**Jeanie Bourke - RE: 31 Pleasant Hill (901 Washington) BP#2014-01693**

**Subject:** Commercial Interior Renovation, 901 washington avenue, Spurwink Services

LIFE SAFETY PLAN AND CODE INFORMATION

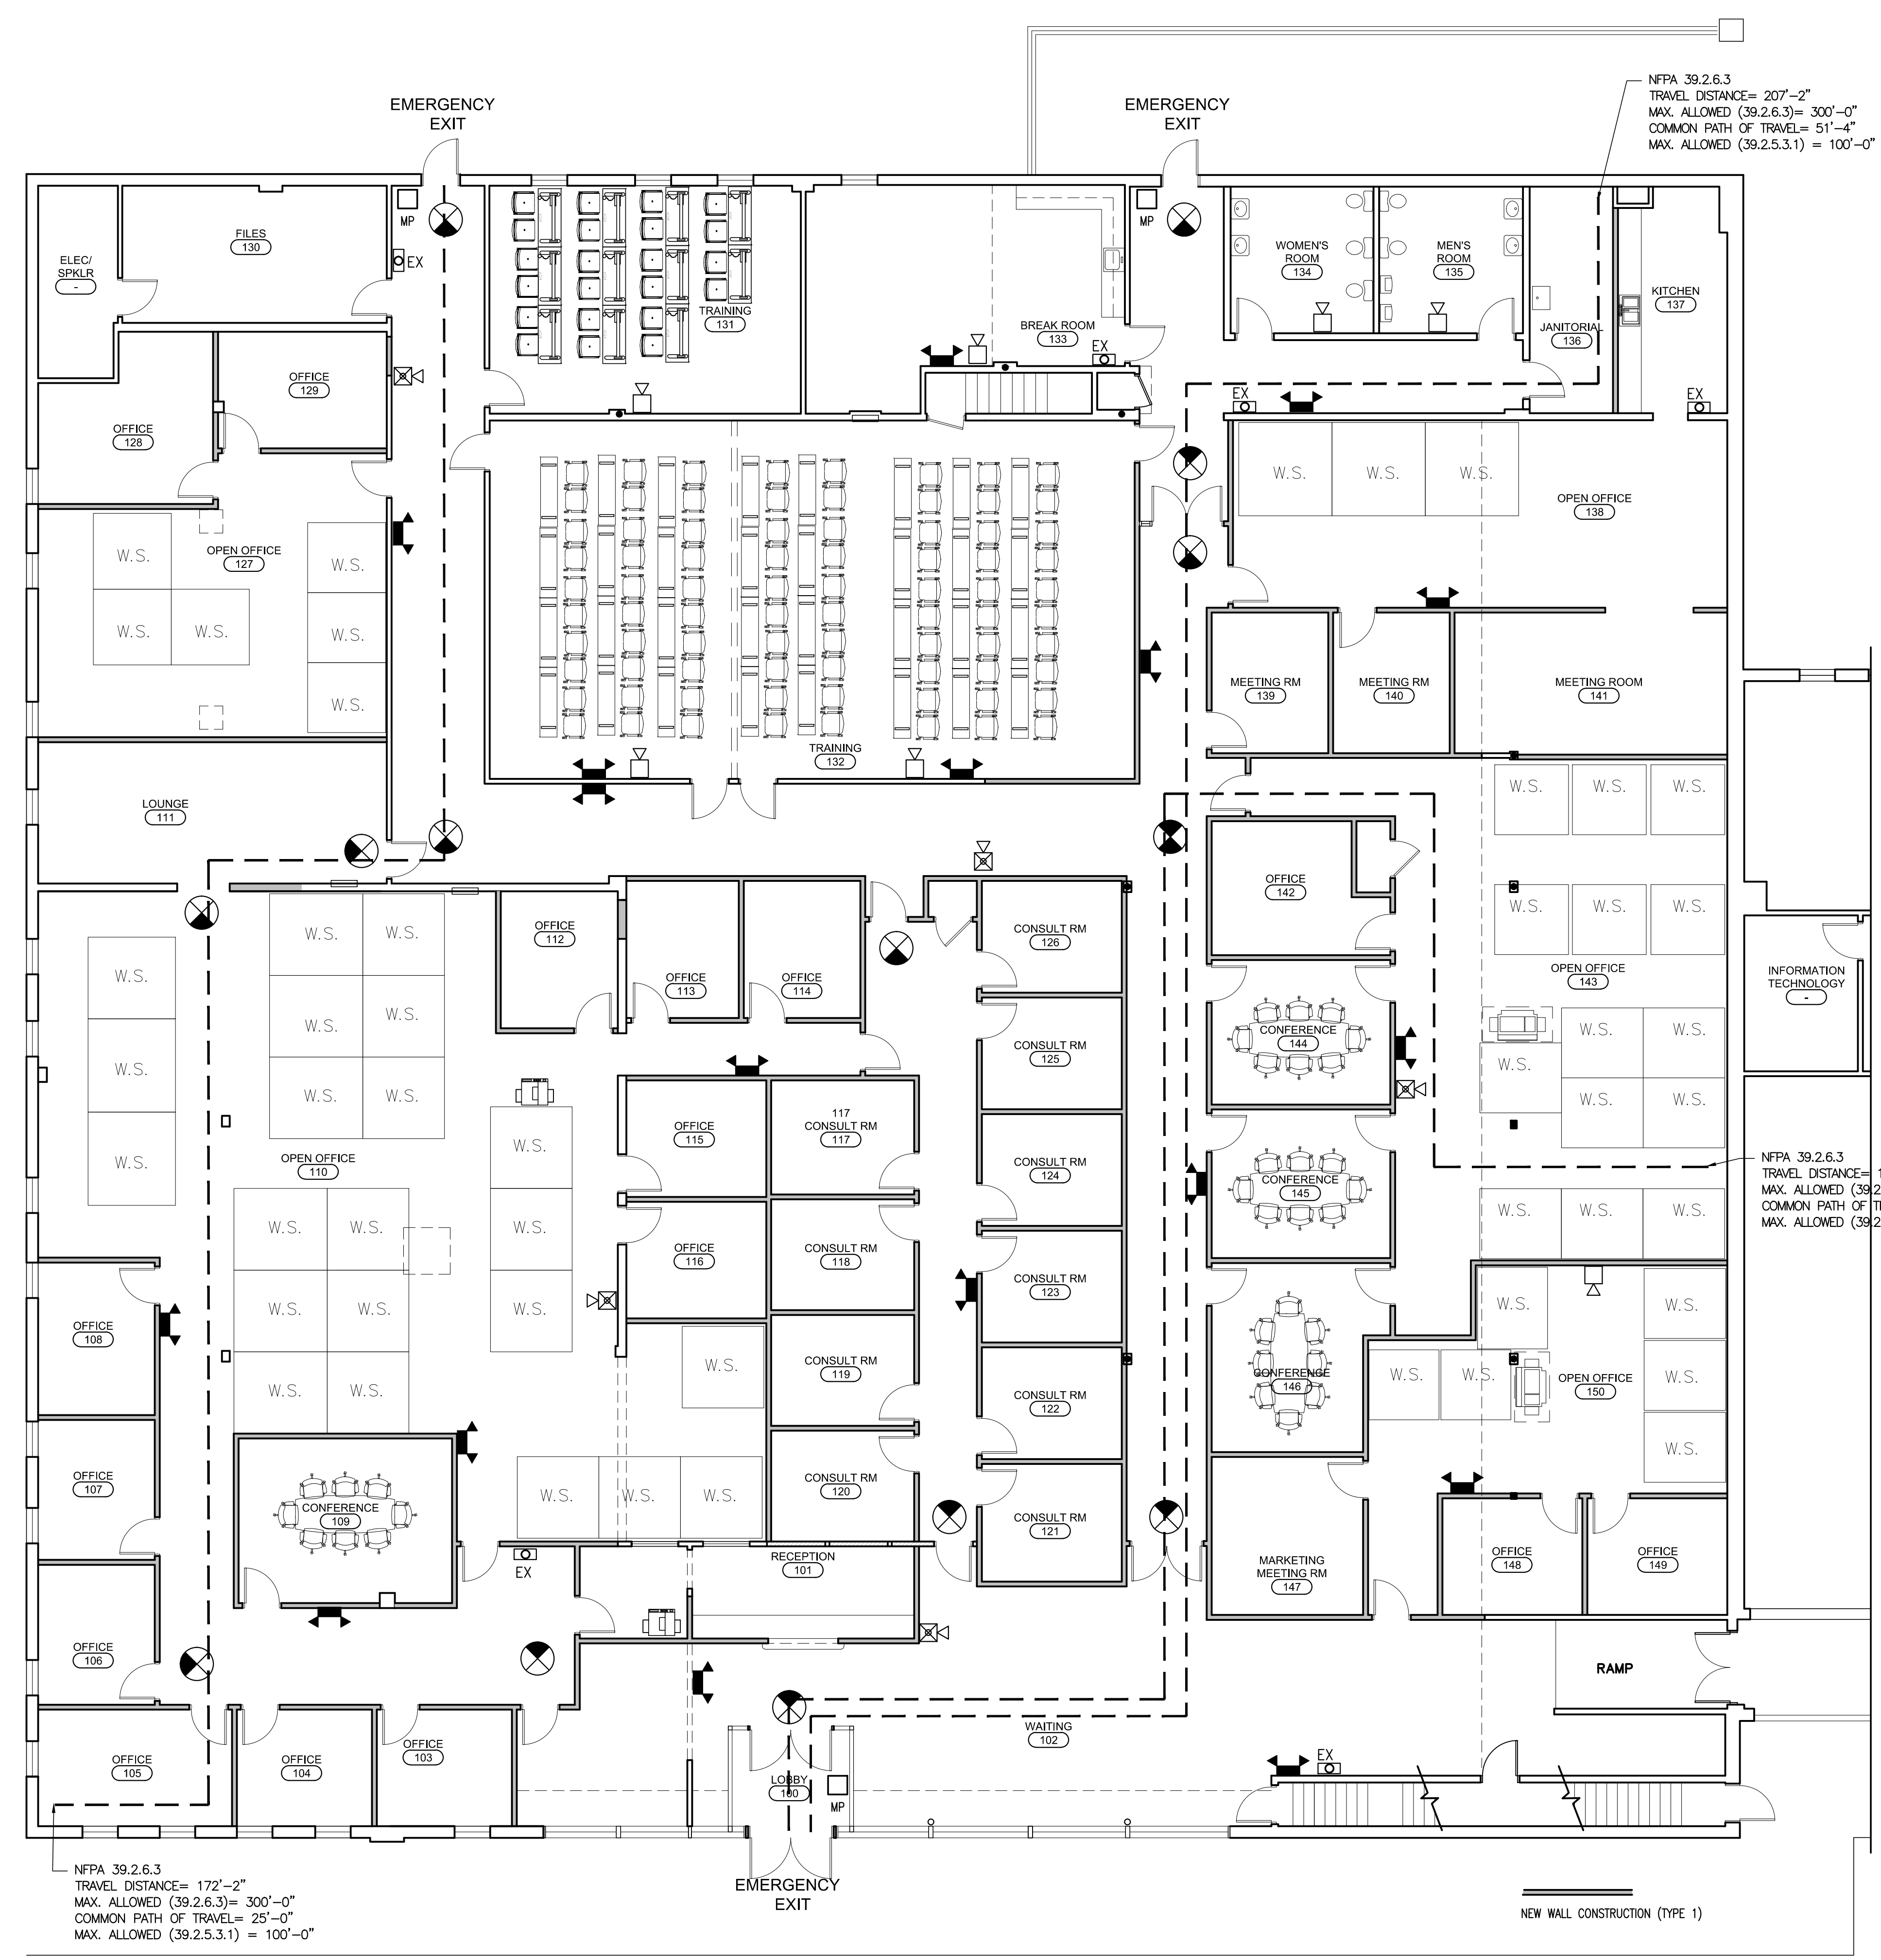
While I have your ear, I spoke with Craig today and he brought to my attention the training room capacity (80+). This room classification is now Assembly. Can you please address this in your IBC code analysis for mixed use, Sec. 508. It looks like this may qualify for the 10% Accessory allowance, however this will be for the aggregate of all assembly uses in any future expansions.

Jeanie, I spoke with Craig last week about the assembly use and separation. He understands that IBC provides an accessory allowance. NFPA 101 sec. 6.1.14.1.3 provides some exceptions for incidental occupancy.

I explained that the existing room is not separated and the occupancy calculation of the existing room is calculated at 86. The renovation is increasing the occupancy of the room by 27. This space is intended to be used by the Spurwink employees for training. Spurwink has indicated that they have a monthly training meeting and the likely occupancy will be approximately 50 employees.

I have updated my drawing FP-1 and added the IBC 508.2, on the Accessory Allowance. The drawing is attached for your review. Do you want me to upload this through the normal channels? Should I cloud the revisions?
